Engineers Comments Regarding Surface Water Drainage

Application No: BN/18/22/DOC
Registered: 23rd February 2022
Site Address: The Cottage Highground Lane Barnham PO22 0BT
Description of Works: Approval of details reserved by condition imposed under ref BN/17/21/PL relating to Condition Nos 3 - materials and finishes, 5 - Construction Management Plan, 9 - Energy Statement, 13 - surface water drainage, 14 - foul water disposal, 15 - Biodiversity Enhancement Plan.

DRAWING TITLE:
PROPOSED DWELLING ADJACENT TO
EXISTING DWELLING
Proposed SWD Design layout

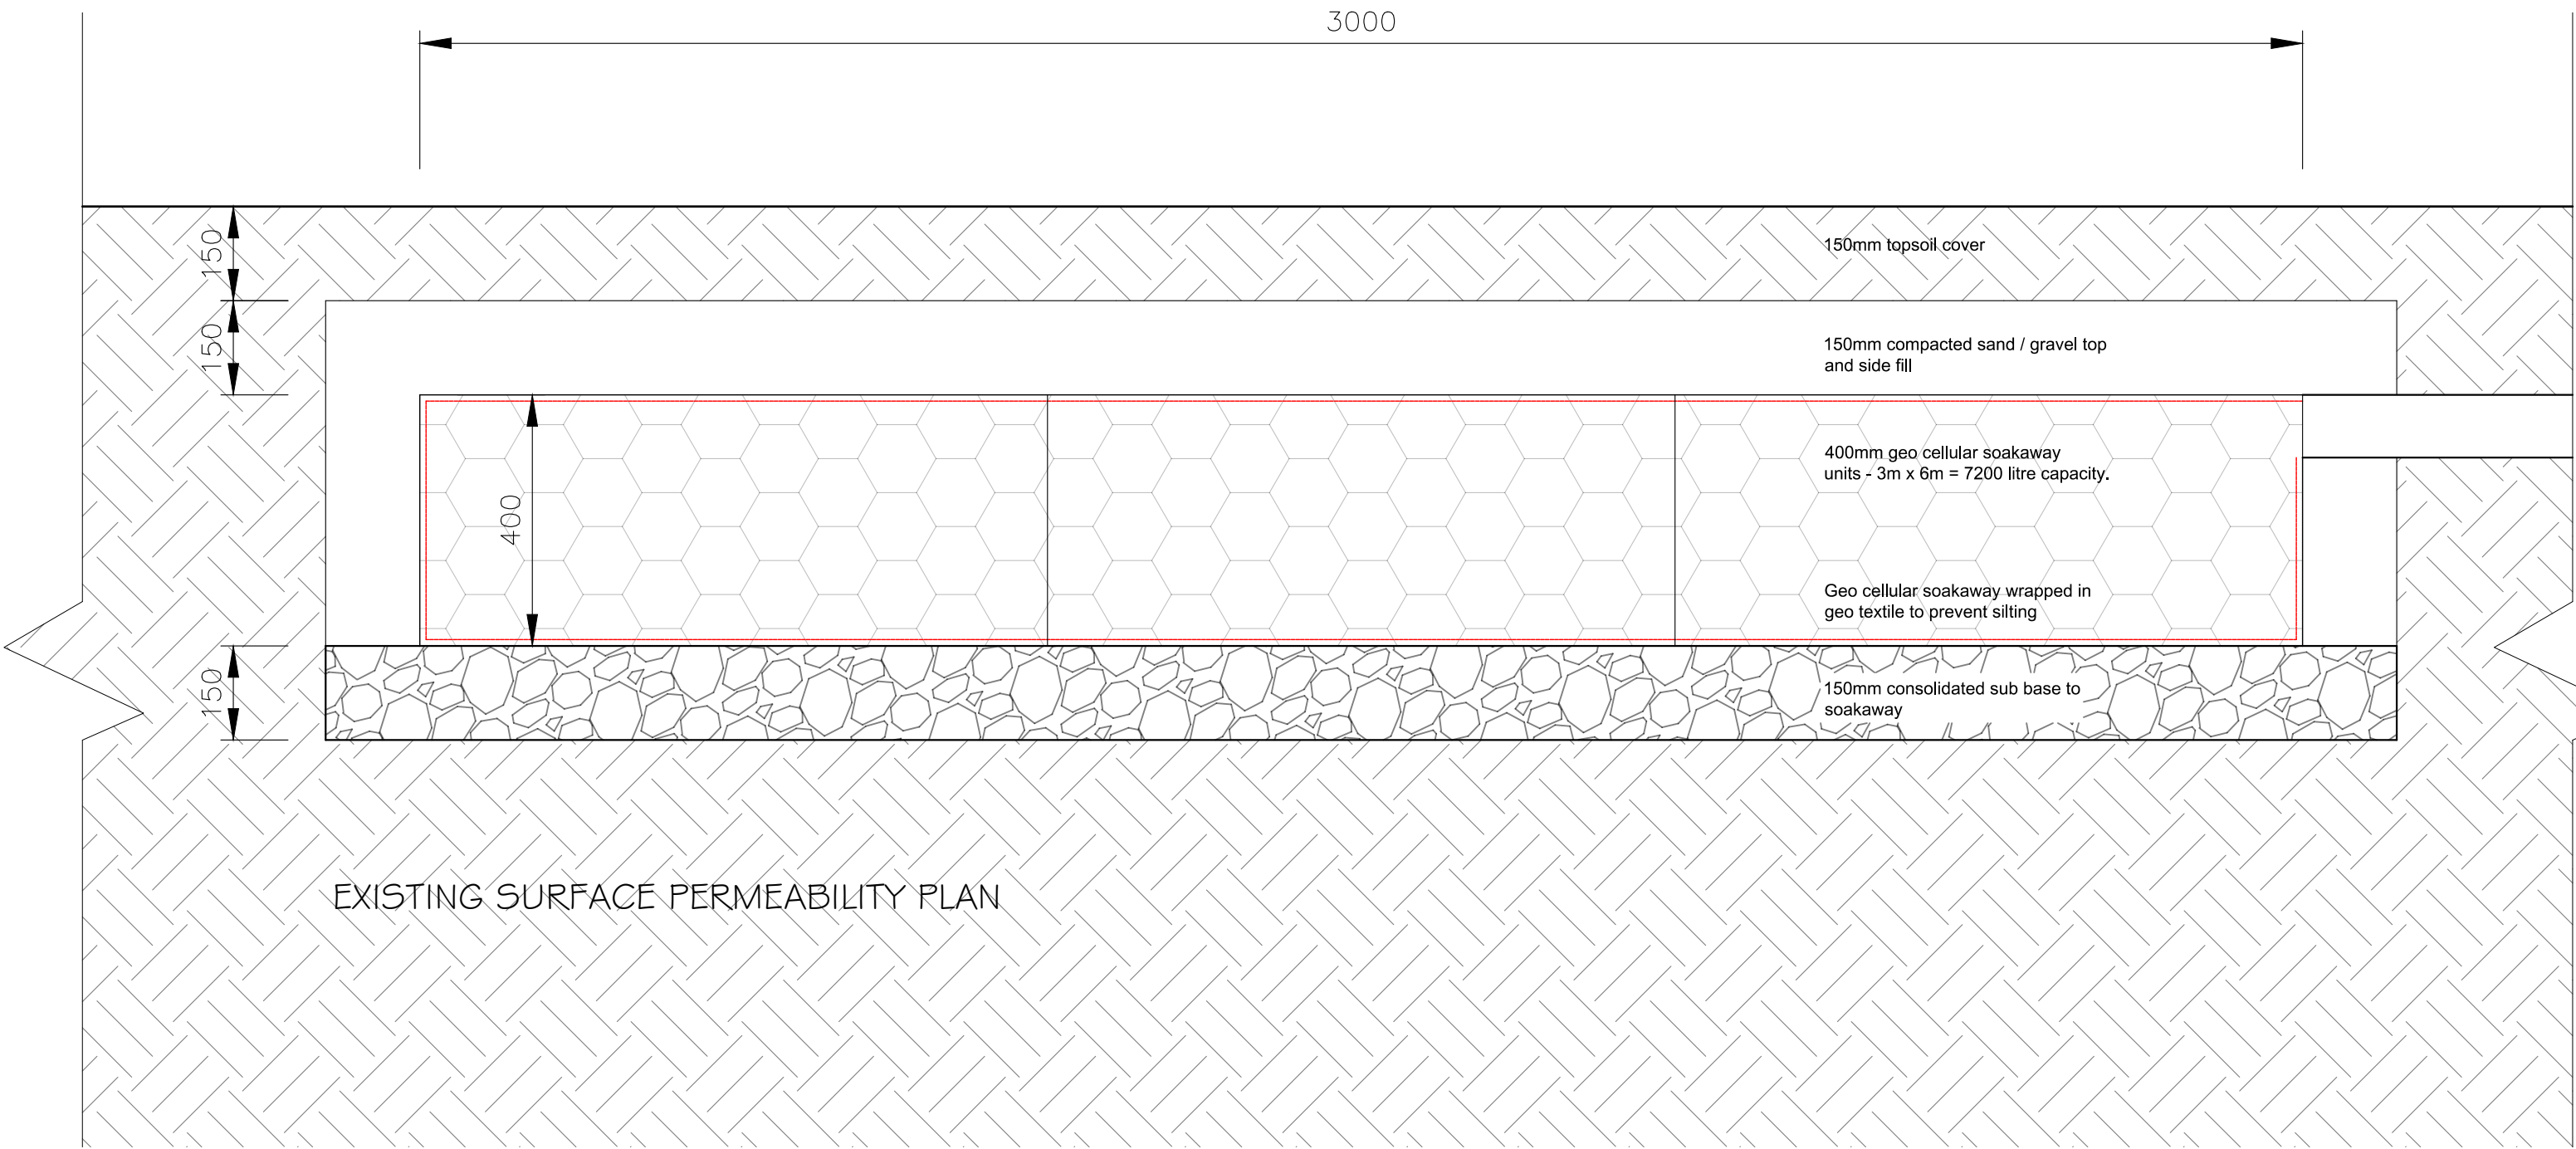
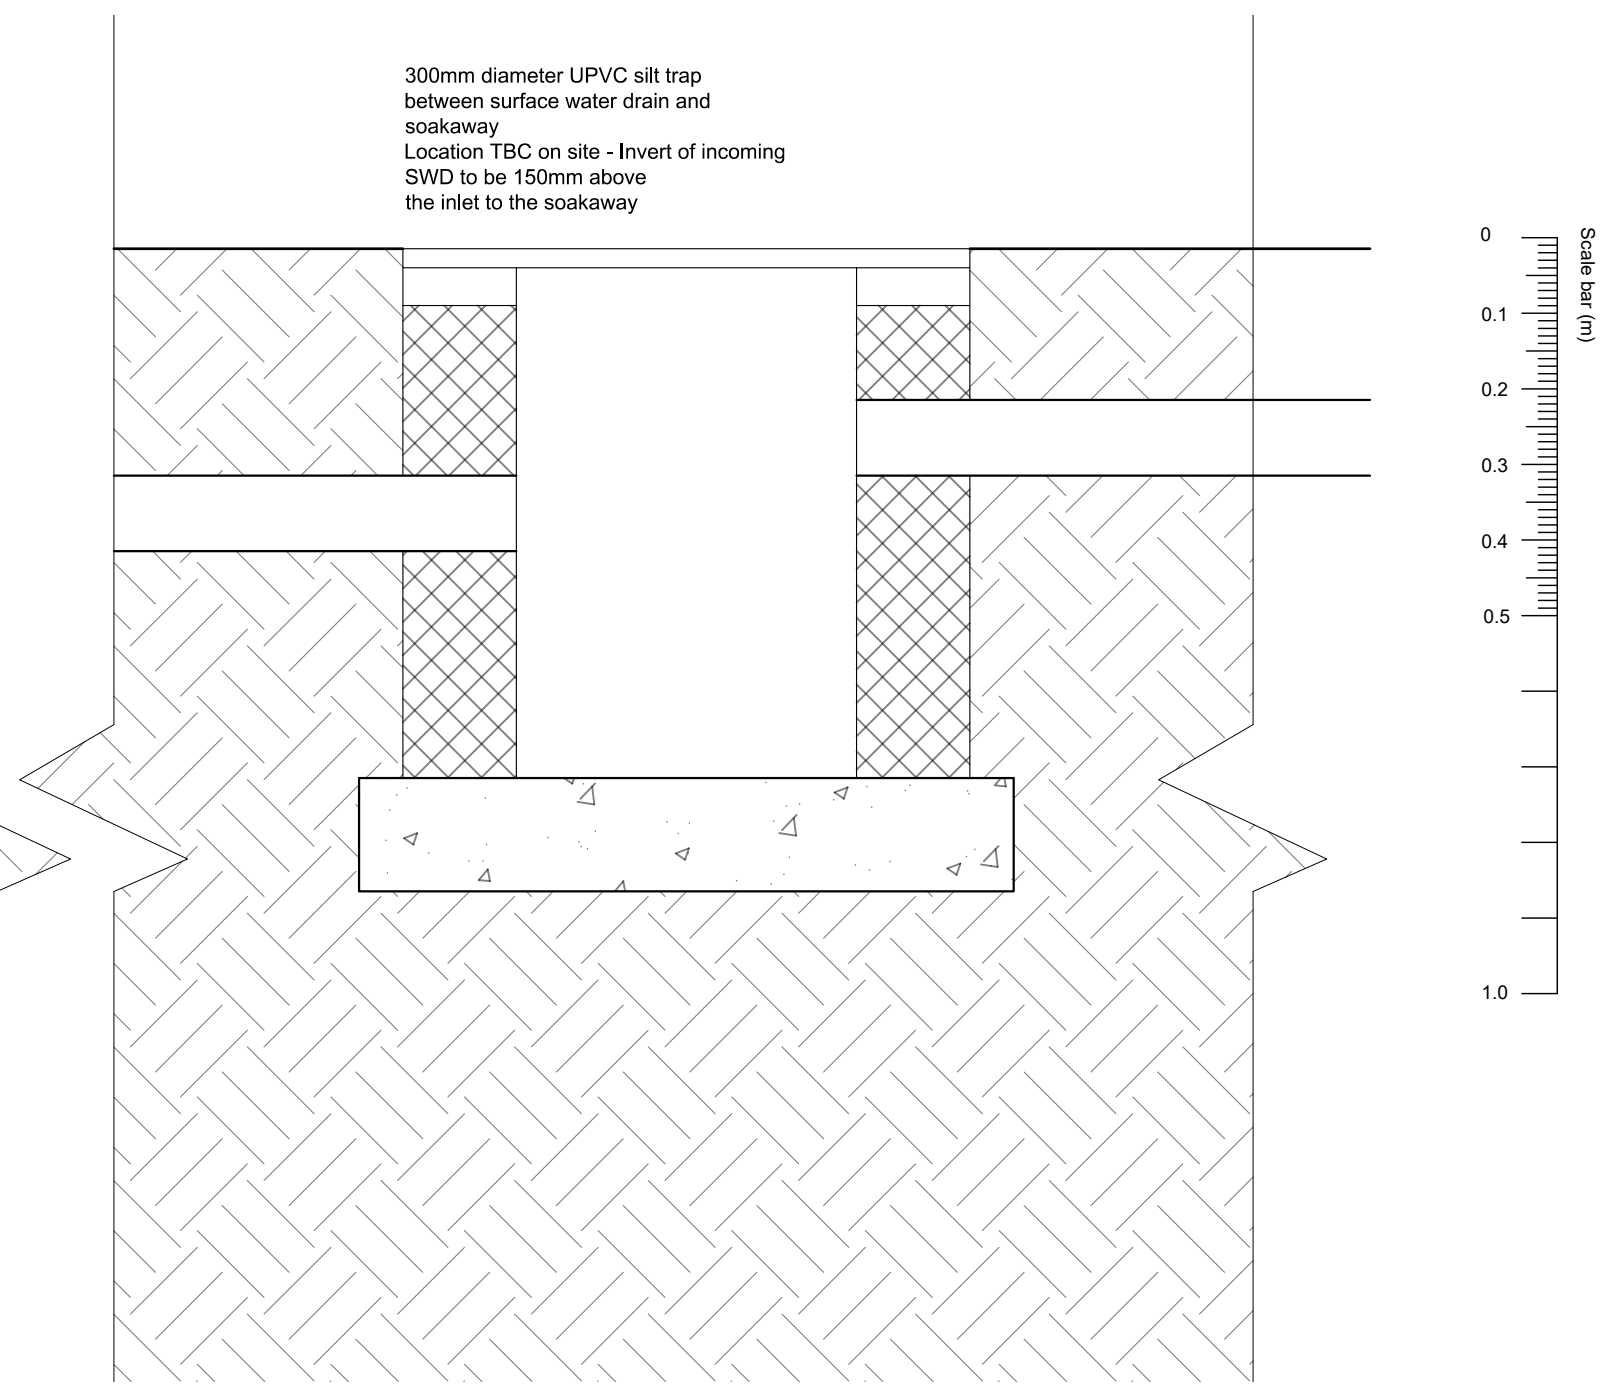
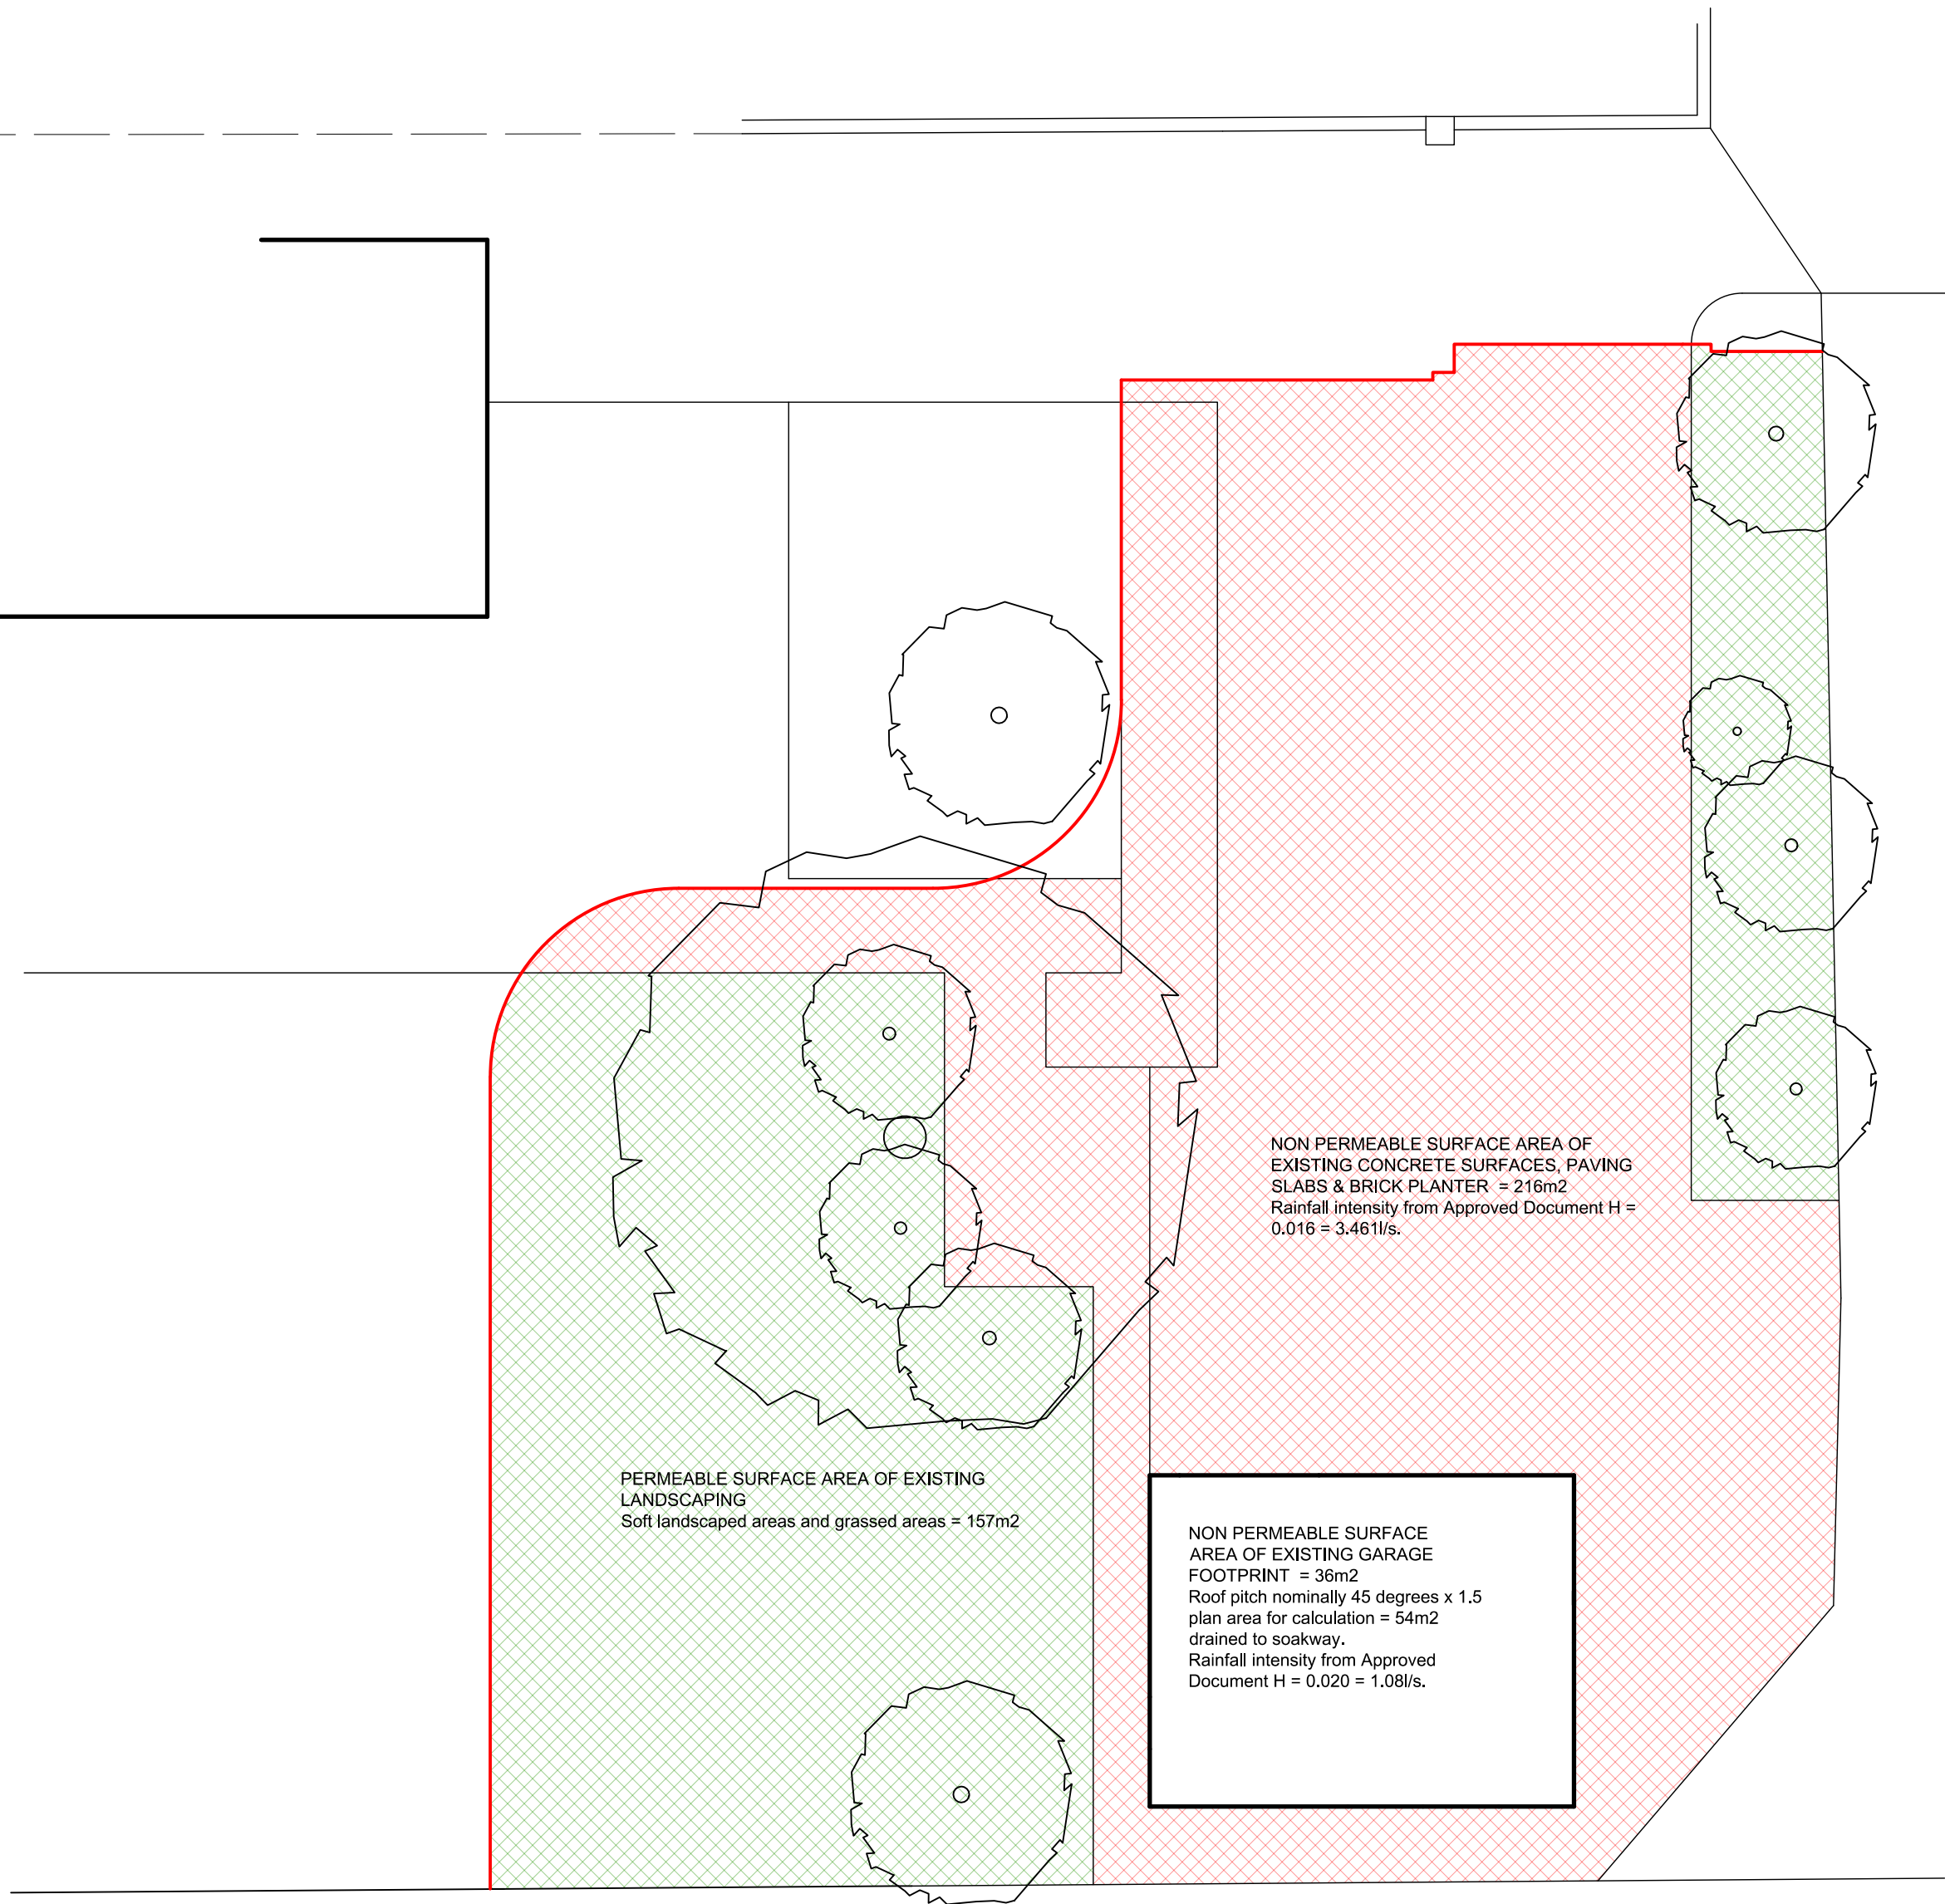
The applicant has supplied a SWD Design Layout Dwg which gives an indication of the proposed strategy. They have also provided a surface water drainage statement which attempts to justify the design.

If the owners of Russet Cottage are agreeable to the use of their data then the applicant will need to submit an updated design, calculations and construction detail drawings. Any reference to the previous use of the site is irrelevant, they will need to design the surface water drainage for the new dwelling to meet current requirements.

It is worth pointing out at this stage that the new design must not locate the soakaway within any tree root protection zones. The current proposed location would be unacceptable for this reason.
